SITE PLAN
 SCALE: 1"=20'-0"

VALLEY STREET
 NEW BUILDING
 1450 VALLEY STREET
 COLORADO SPRINGS, CO 80939
 EL PASO COUNTY, COLORADO

DATE: NOV. 7, 2022
 DRAWN BY: W. VENEROS
 PROJ. MGR: P. HOLLI-ARCUS
 SCALE: SEE PLAN
 APPROVED BY:
 JOB NO: 1304

1 SITE PLAN
SCALE: 1"=20'-0"

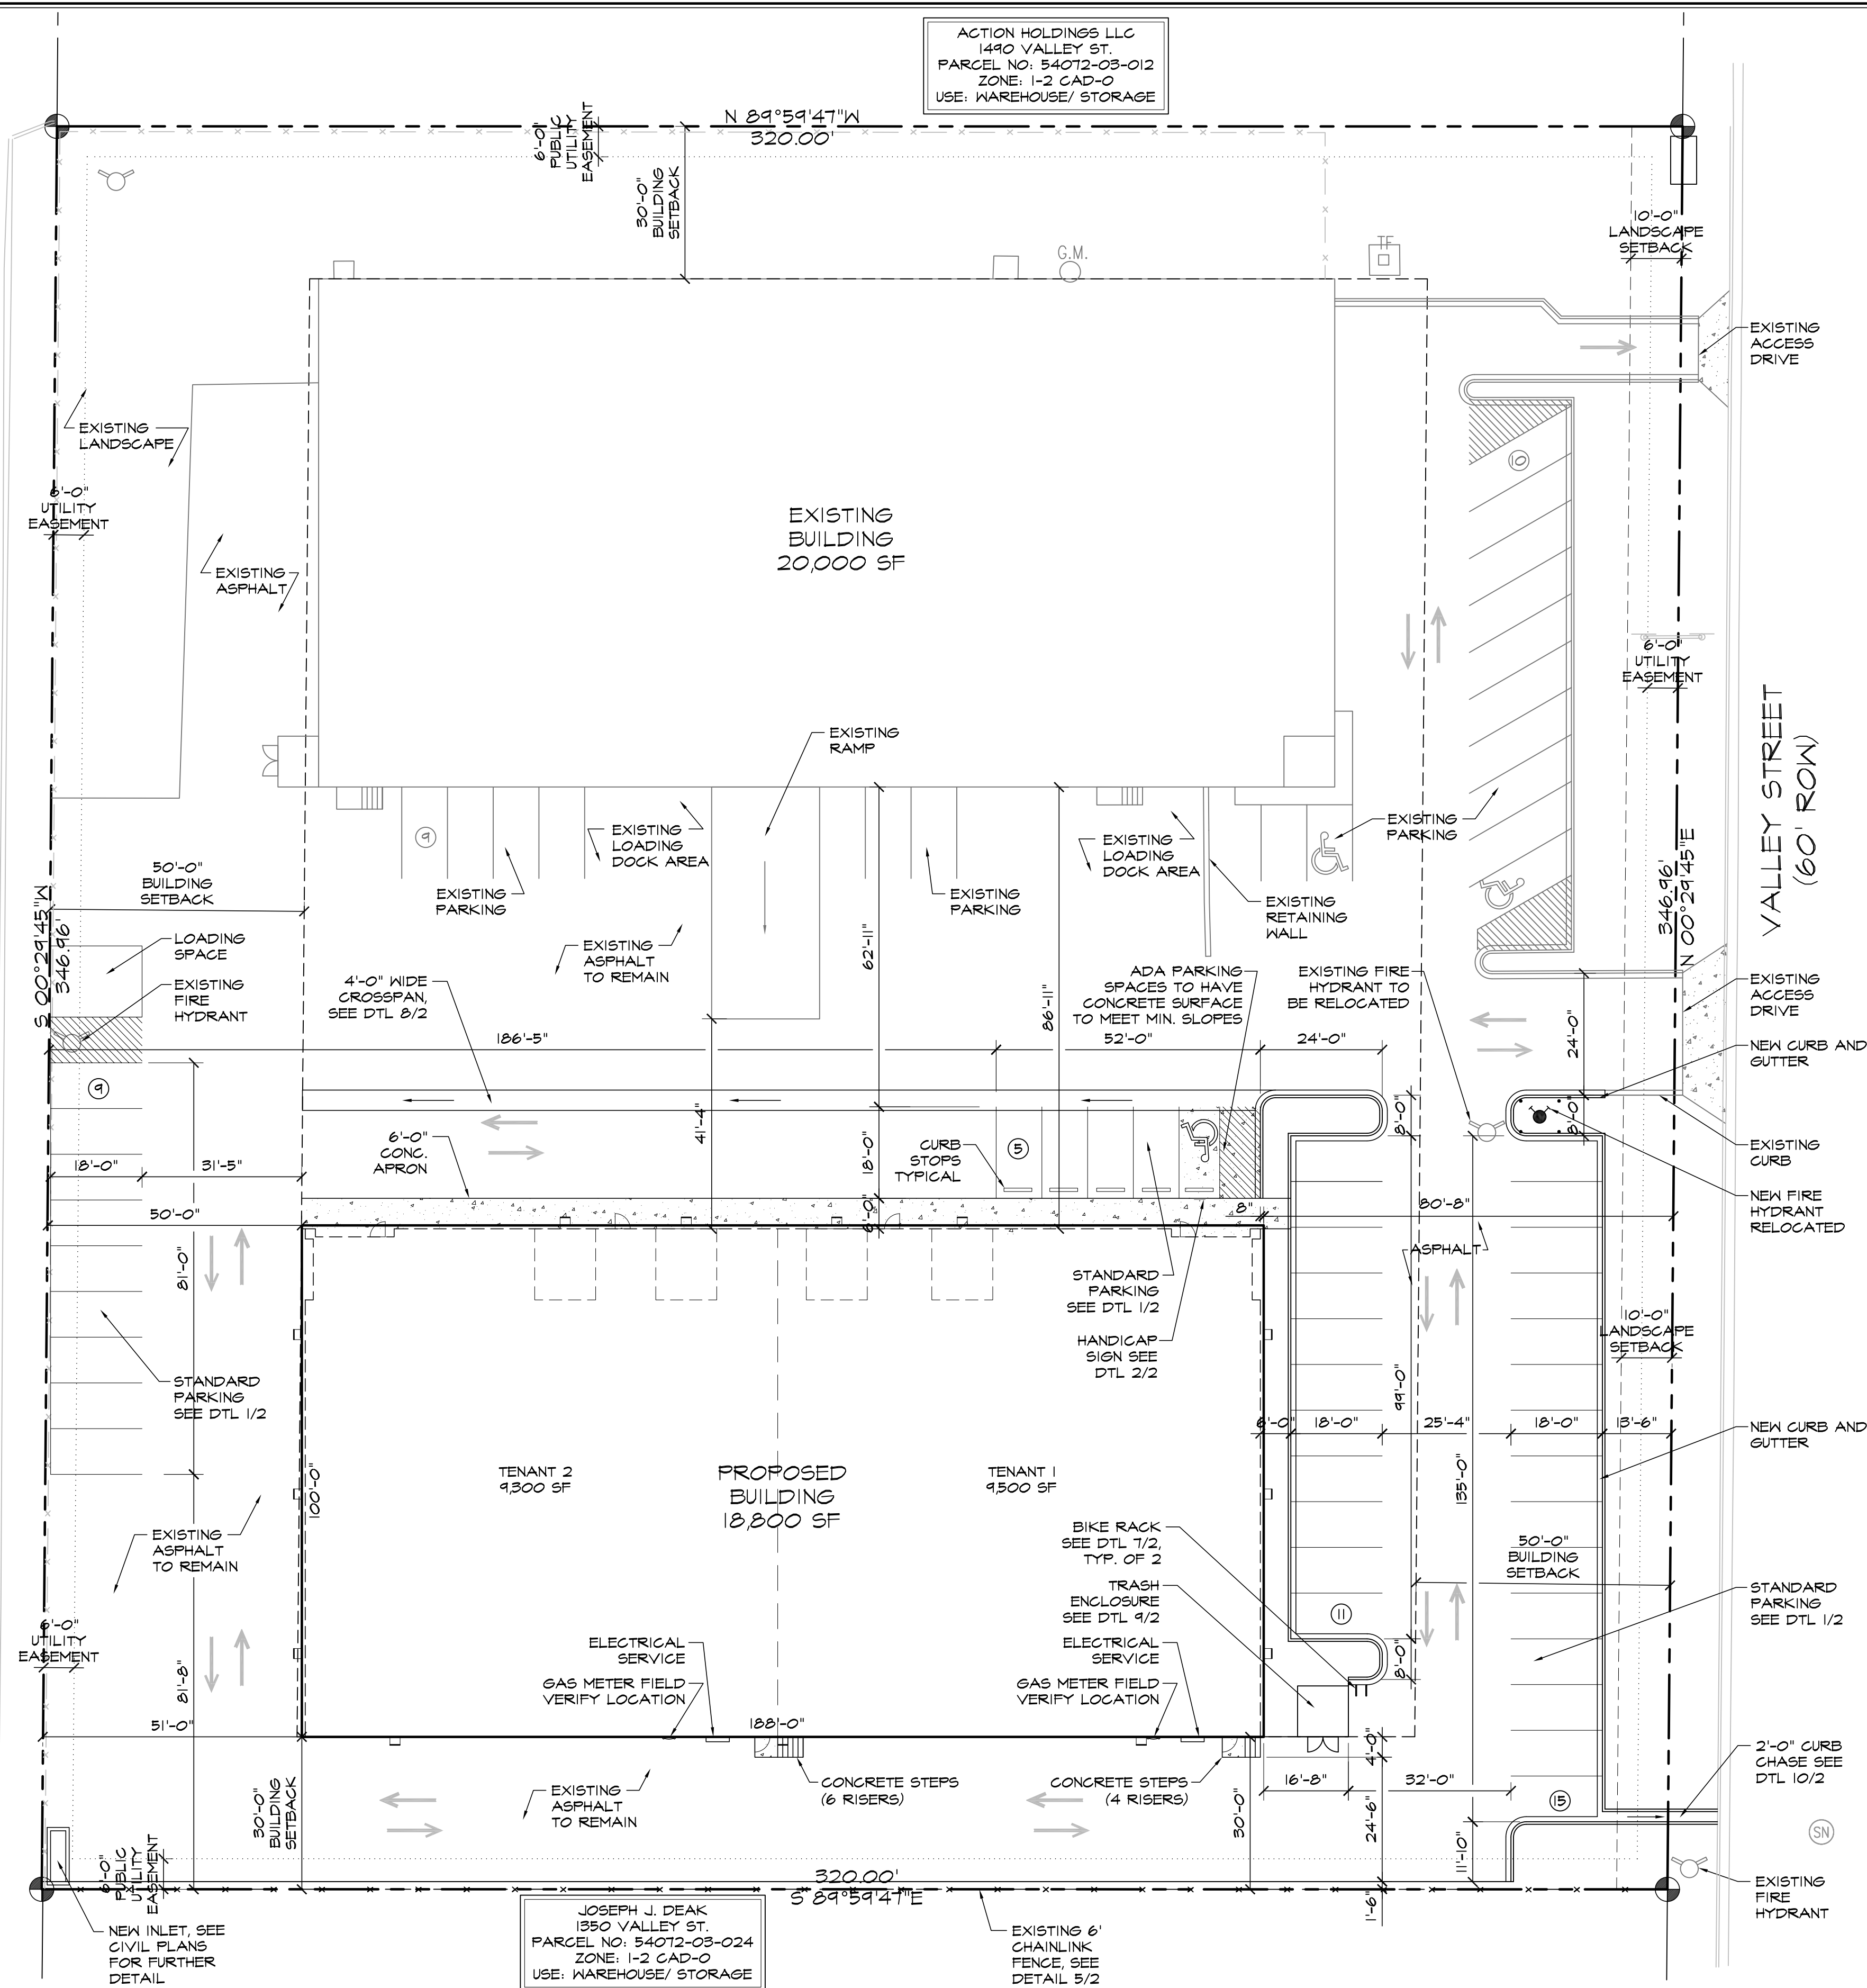
Please add the following note to the site plan:
 - The parties responsible for this plan have familiarized themselves with all current accessibility criteria and specifications and the proposed plan reflects all site elements required by the applicable ADA design standards and guidelines as published by the United States Department of Justice. Approval of this plan by El Paso County does not assure compliance with the ADA or any regulations or guidelines enacted or promulgated under or with respect to such laws.

Please include:
 -well and septic sites, if none please specify
 -location of no build areas, if none please specify
 -location of off street parking, if applicable

There is no approved driveway access permit on file for the two existing driveways. Applicant will have to apply for driveway access permits prior to building permit approval. Additionally, the maximum number of driveways allowed for the parcel is two (2). Applicant will have to close one of the existing driveways prior to construction of the proposed driveway.
